Our ref: DOC19/110341

NOTICE OF EXHIBITION FOR REDEVELOPMENT OF GREENWICH HOSPITAL AT 97-115 RIVER ROAD, GREENWICH (SSD 8699)

As delegate of the Heritage Council of NSW, I provide the following comments:

Figure 5.1 Plan of the study area showing assessed historical archaeological potential. (Source: SIX Maps with GML additions 2017)

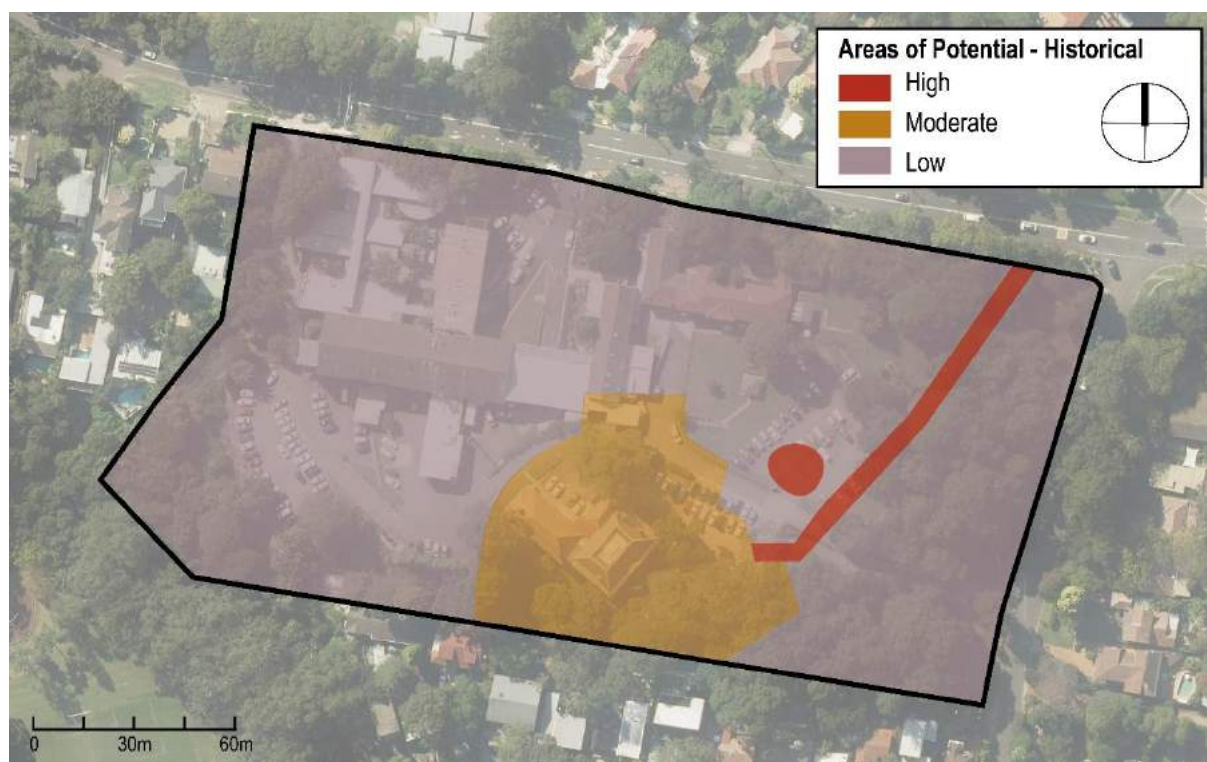
- **Historical Archaeology:** The GML Historical Assessment has identified there is potential for locally significant archaeological resources to remain in parts of the site (GML, 2018: Figure 5.1, p35). These areas are focused on 'Pallister' in the south of the site and in the connection to River Road along the eastern part of the site within the SHR curtilage. However, the assessment has not clearly explained how the identified archaeological resources would satisfy local levels for the post 19th century and late 19th century features identified in Table 5.2 (GML 2018: p35-36). To confirm that significance and appropriate management responses, the Division supports the approach to undertake earlier physical investigation of the areas of archaeological potential where works involving ground disturbance, as modified by the above Heritage Division comments are adjusted, to inform the final design of the redevelopment. This should also inform the interpretation of Pallister as an item of State heritage significance, which is also recommended above. This approach is supported as the remains in these areas may not retain archaeological research potential, but former remains of e.g. earlier structures such as the observatory, are significant for other values within the SHR site. Interpretation of these elements as a result of earlier archaeological investigative techniques for the site within the broader redevelopment is supported.

- Historical Archaeology: The proposed approach to conduct early archaeological testing to understand the archaeological research potential, management in terms of amended design recommendations (as identified in this letter), and to inform the interpretation of Pallister is supported. To assist this the following requirements are recommended (as standard conditions to manage the archaeological activity):
